**City of Portland, Maine - Building or Use Permit Application**

Permit No: 10-0968	Date Applied For: 08/09/2010	CBL: 183 A014001
-----------------------	---------------------------------	---------------------

Proposed Use: Single Family Home - amend permit# 100748 to change size of deck from 5' x6' to 6' x 10'	Proposed Project Description: amend permit# 100748 to change size of deck from 5' x6' to 6' x 10'
---	--

DECK FOR SUNROOM ENTRANCE

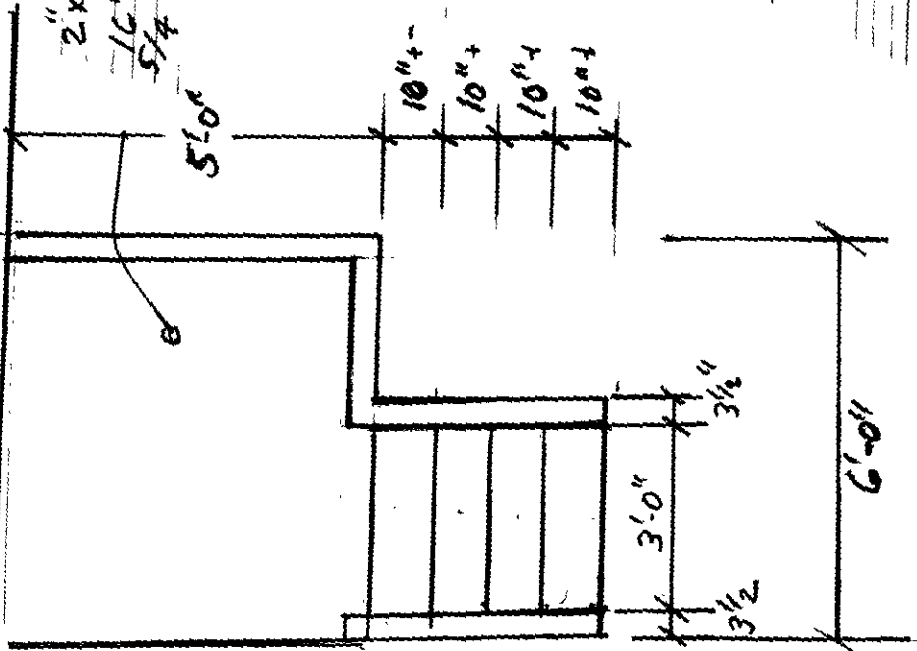
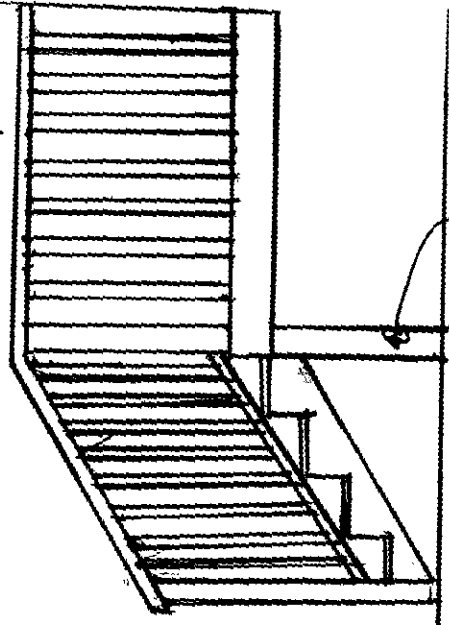
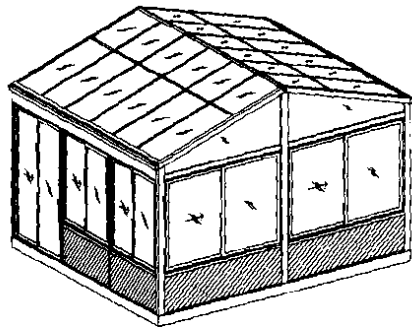
- 1) Permit approved based on the plans submitted and reviewed w/owner/contractor, with additional information as agreed on and as noted on plans.
- 2) Fastener schedule per the IRC 2003
- 3) Frost protection must be installed per the enclosed detail as discussed w/owner/contractor.

9/14/2010-jrioux: Deck cantilever reviewed/ corrected with Contractor at counter; frost protection will be provided.
